# Response to Submissions

100 Bennelong Parkway, Sydney Olympic Park  
SSD 6246

19 November 2014

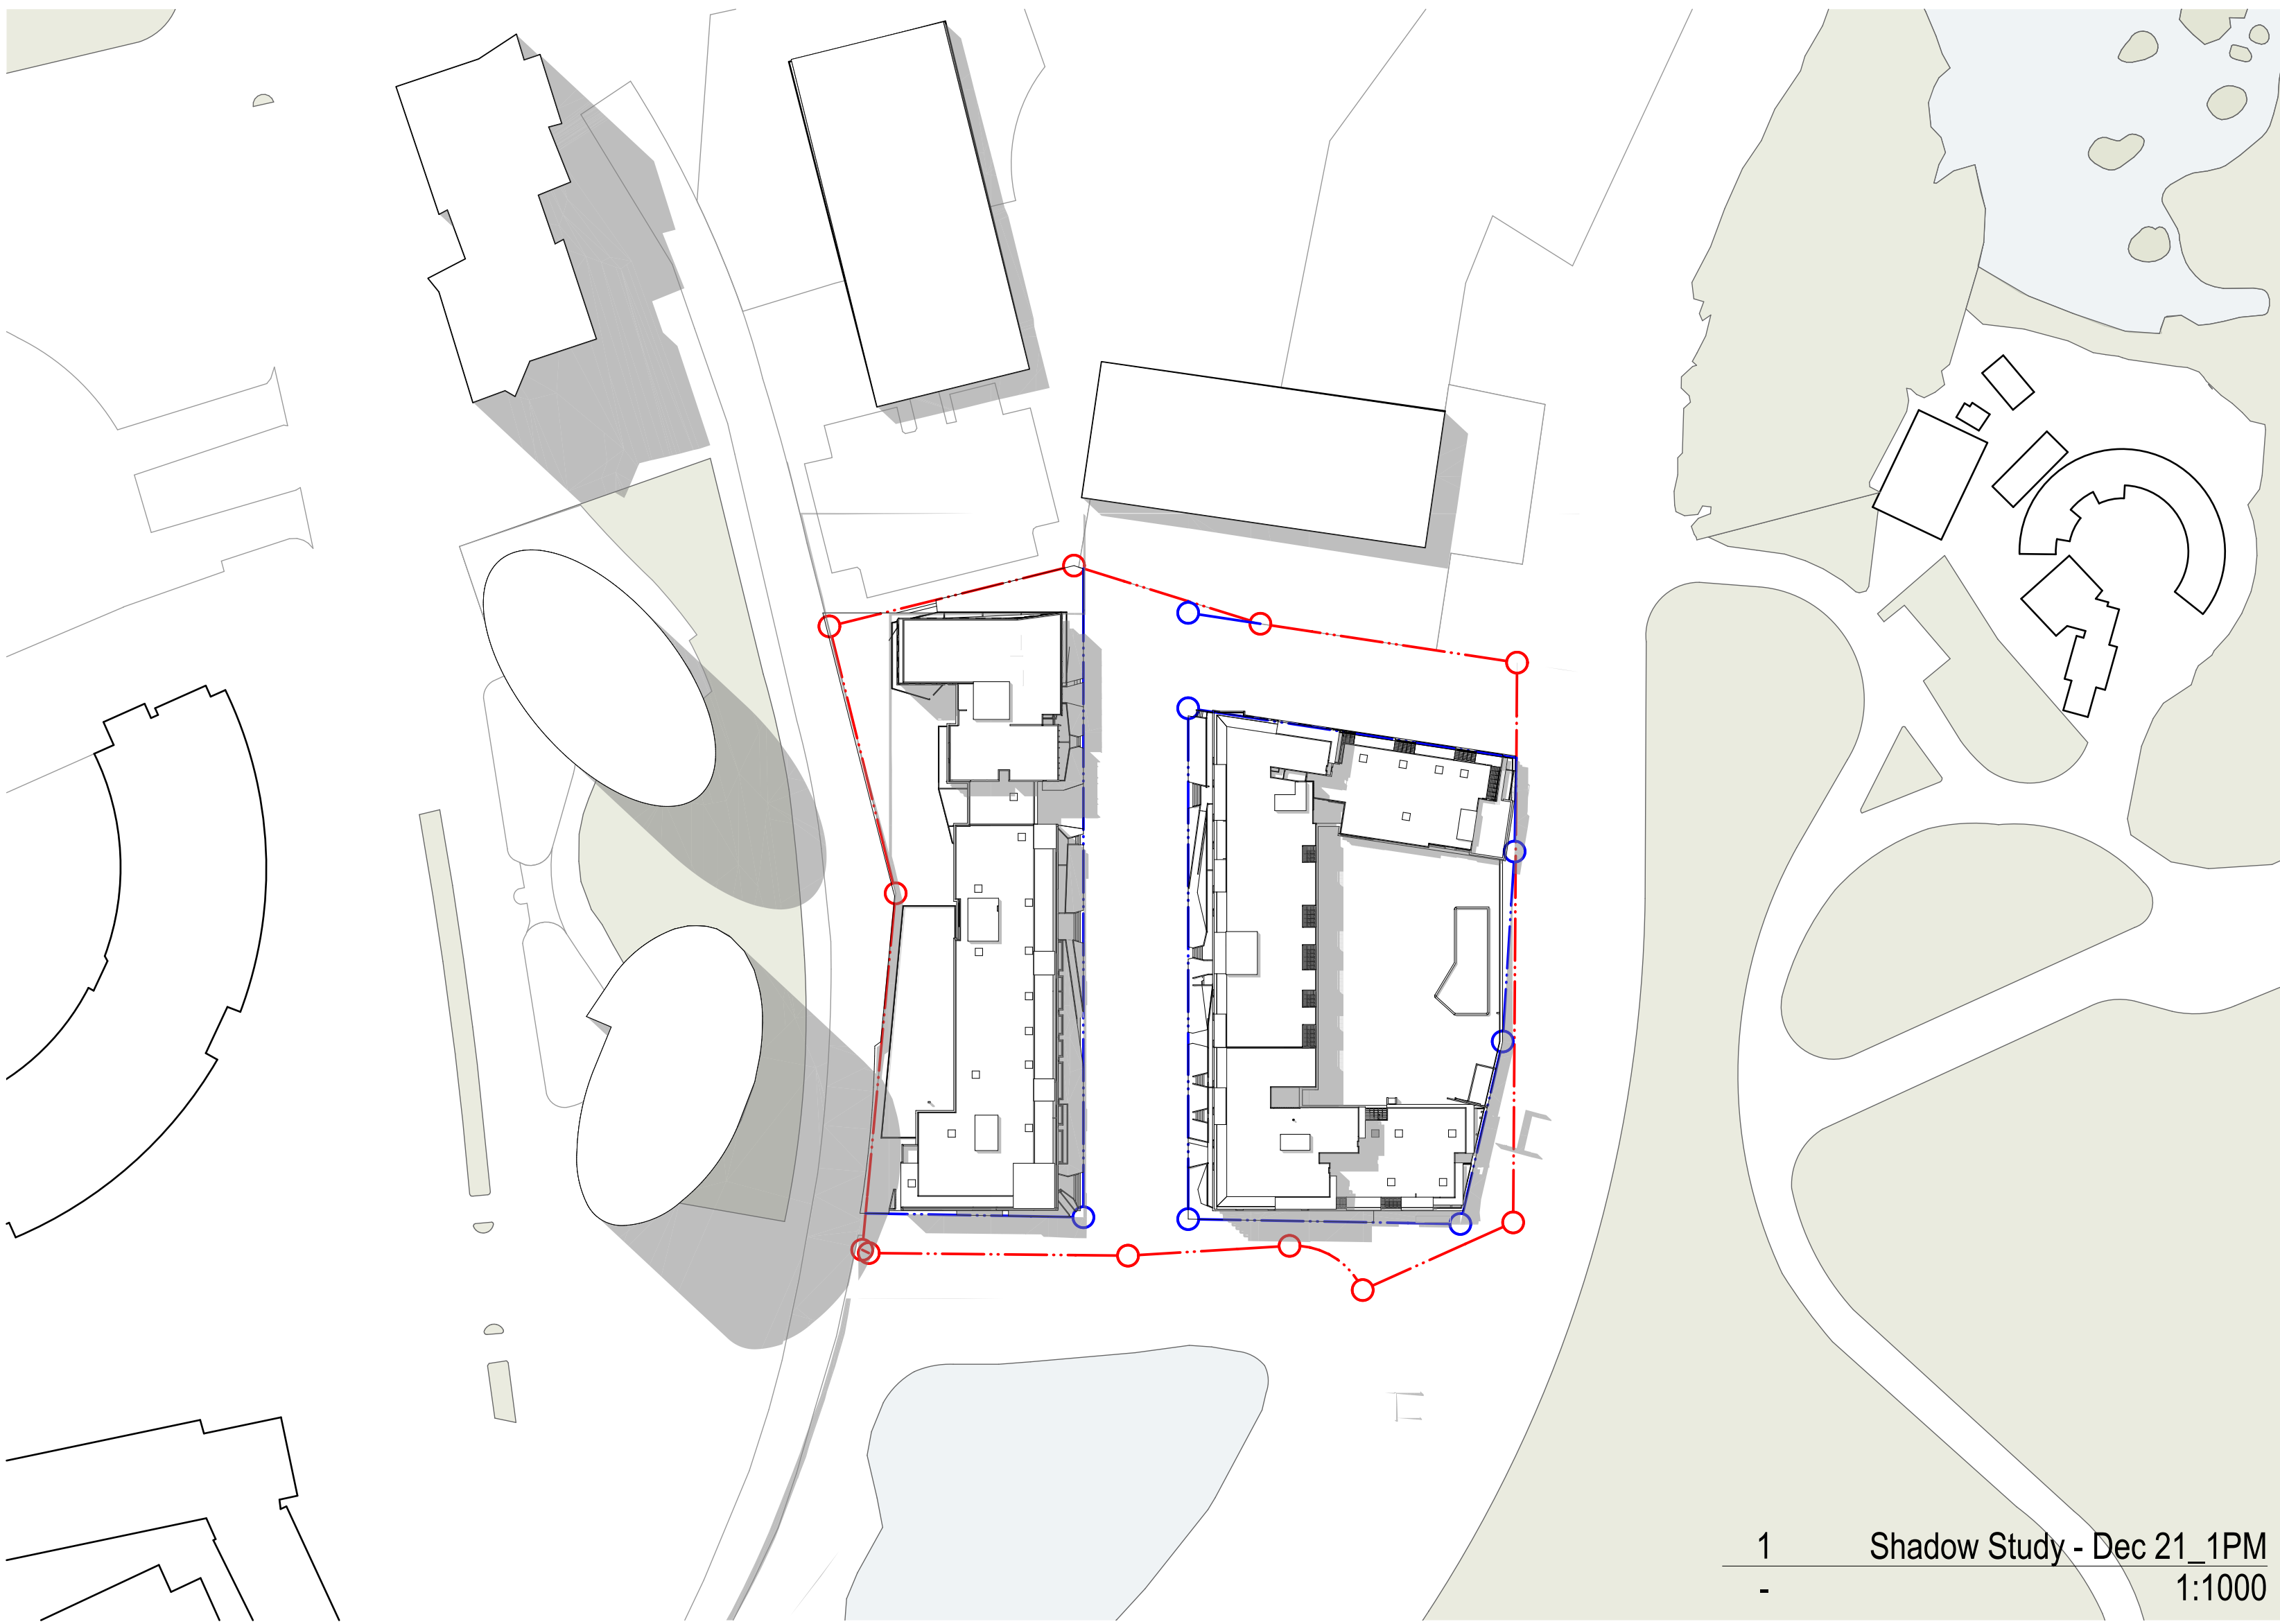
SOPA seeks compliance with the solar access requirements of both the SOPA Masterplan and the 3-hour category of the Residential Flat Design Code.

The proposal has been designed with the footprints of the buildings to accord with the SOPA Masterplan. Further, solar access to the site is adversely affected from 2.30pm onwards by the existing towers to the west of the site. **Figure 1** below contains an extract from the solar access report. It shows that from 2.30pm onwards, the subject site is affected by the buildings to the west in terms of solar access. The extent of this impact is great enough to prevent full 3-hour compliance, as units on the western side of the development will begin to lose sun from this time of the day onwards.

Substantial work has been done on the amended proposed plans (refer **Annexure 3**) to improve solar access to the proposed units. **Annexure 4** contains a solar access report prepared by SLR Consulting assessing the amended development. The following table presents an overview of the SOPA and RFDC requirements and solar access results of the amended proposal.

In order to fully comply with the solar access requirements of the above, the proposal would need 10 more units with 3 hours solar access to comply with the SOPA MP; and 5 more units with 3 hours solar access to comply with SEPP 65/RFDC. However, there are significant factors influencing the ability of the development to fully comply with the solar access requirements of both controls.
